**EL PASO COUNTY PLANNING AND
 COMMUNITY DEVELOPMENT
 DEPARTMENT**

GRADING AND EROSION CONTROL PLAN CHECKLIST

Kiowa Proj. No. 16028
TAP M240-162
SubAcct No.20391
Sheet Number GEC 1

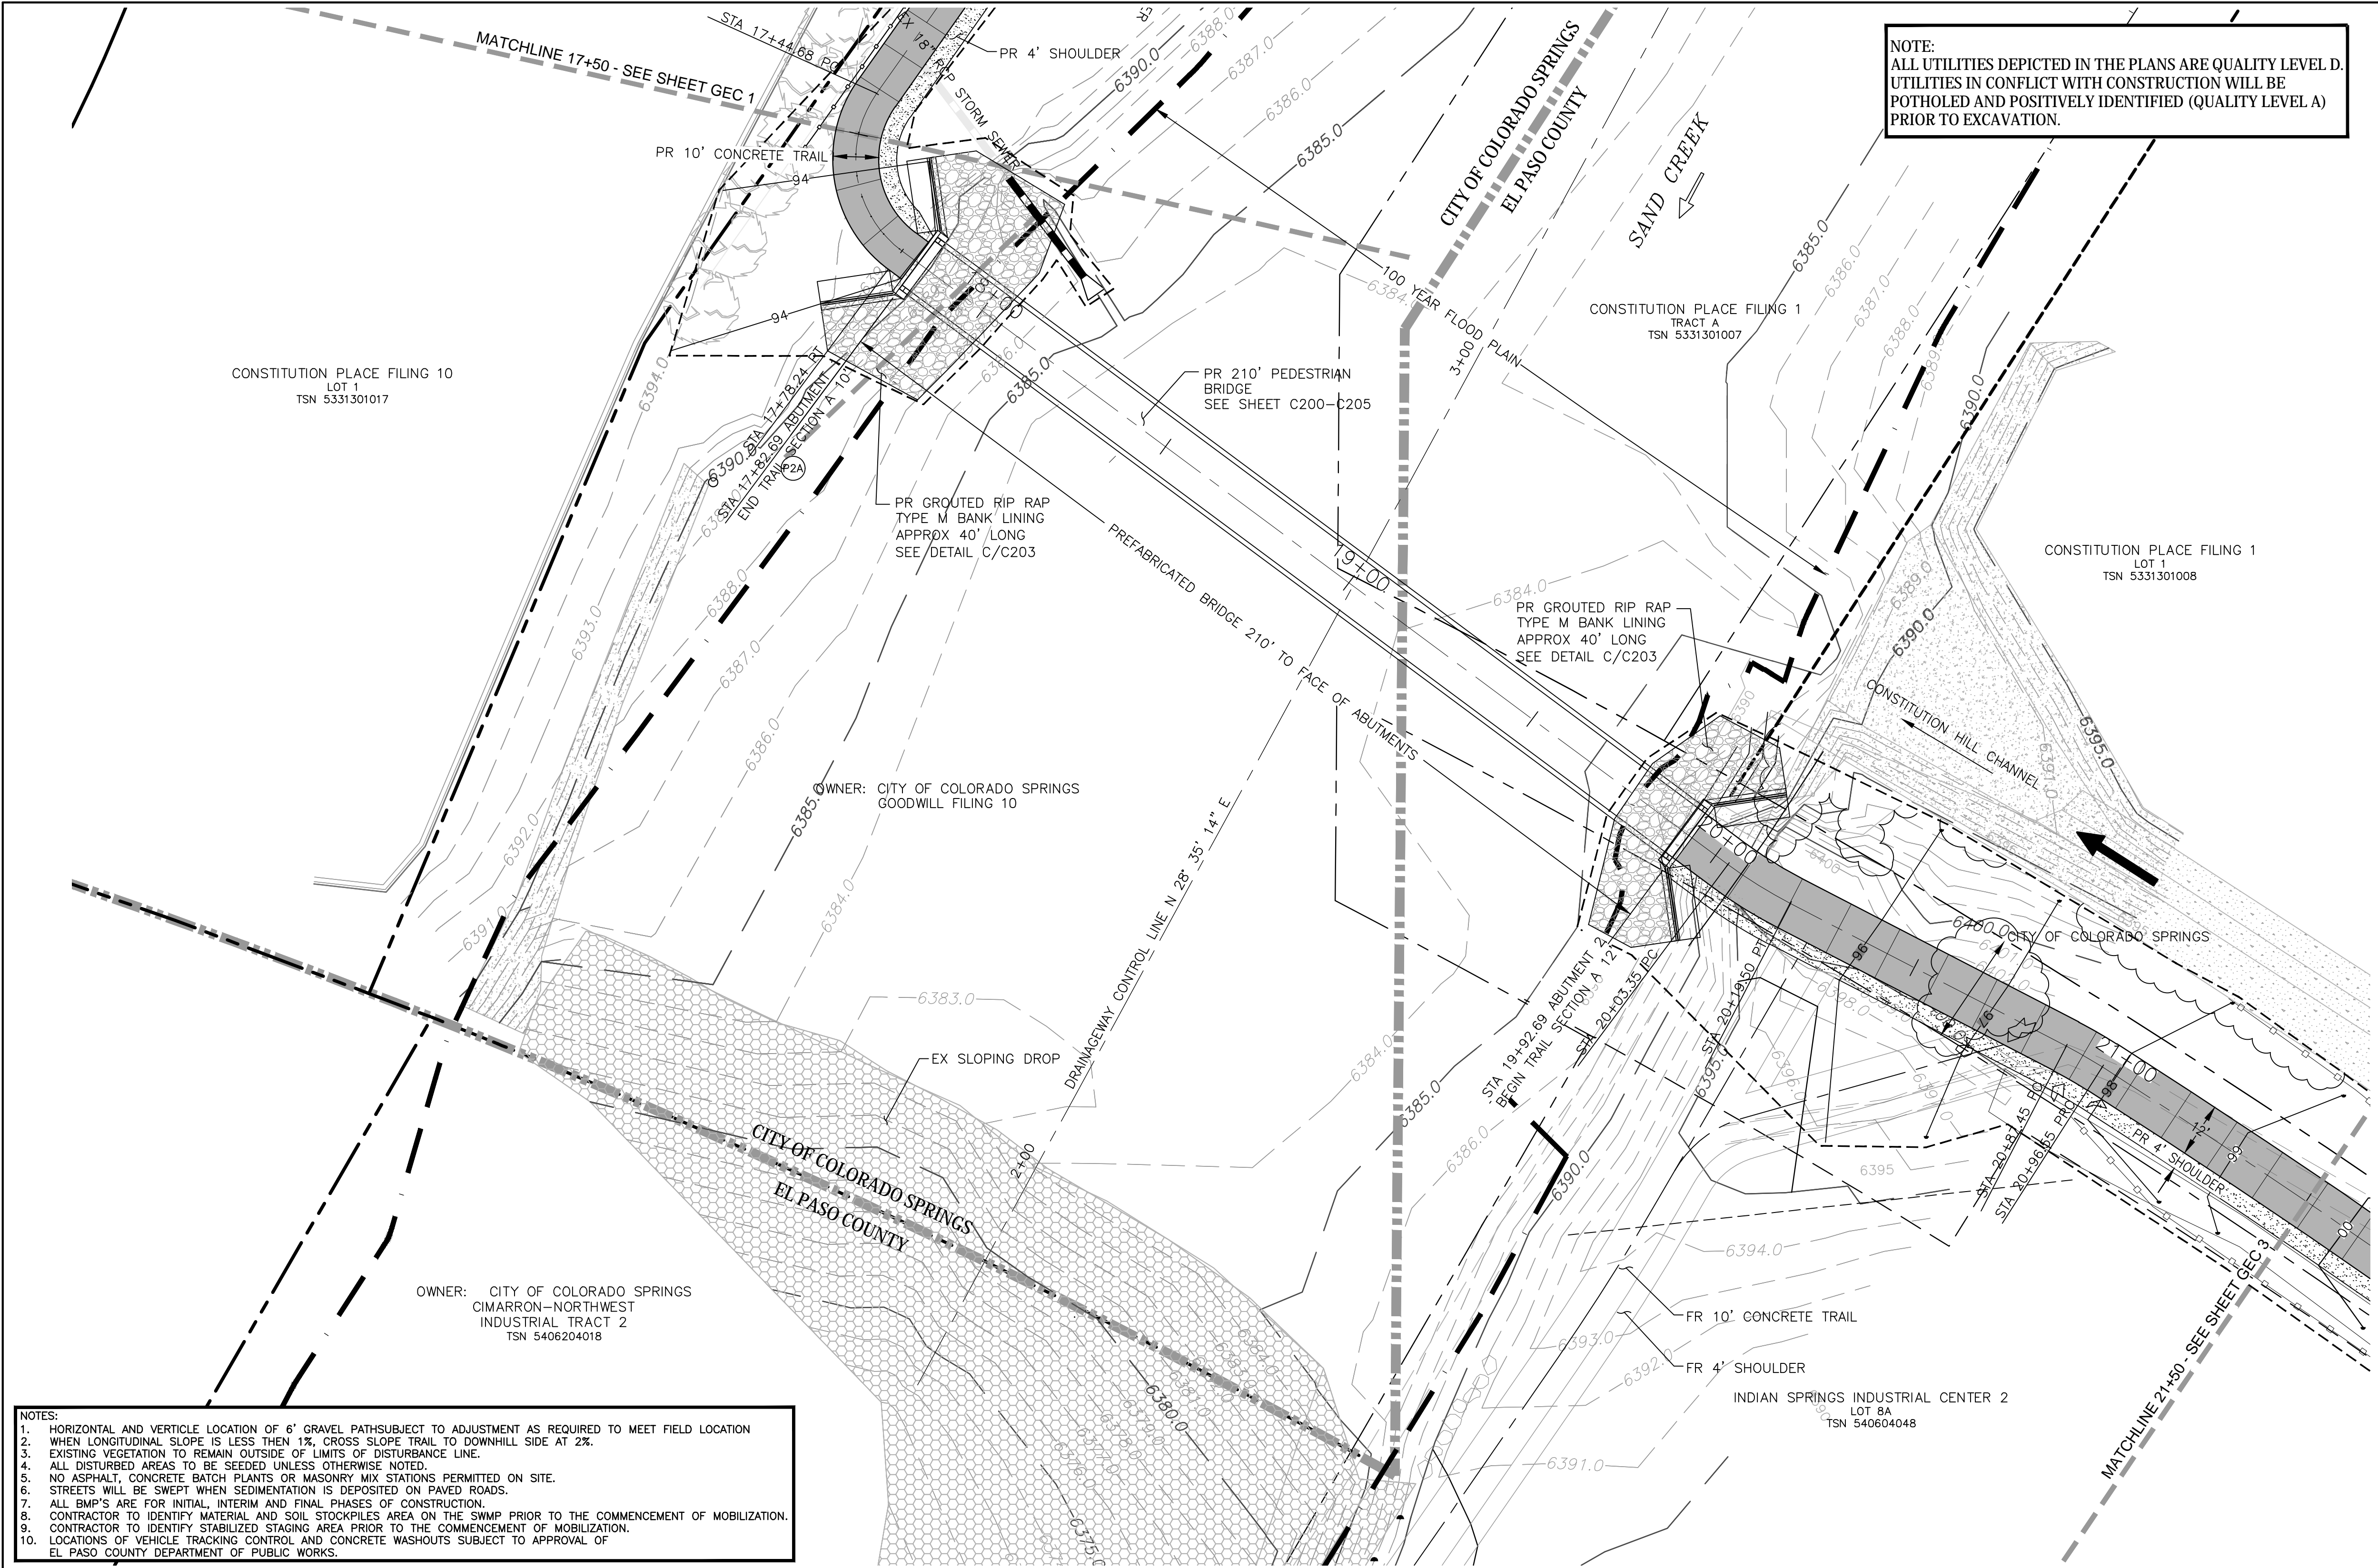
Contours were not legible on the GEC plan.

3:1 slopes identified without erosion blankets.
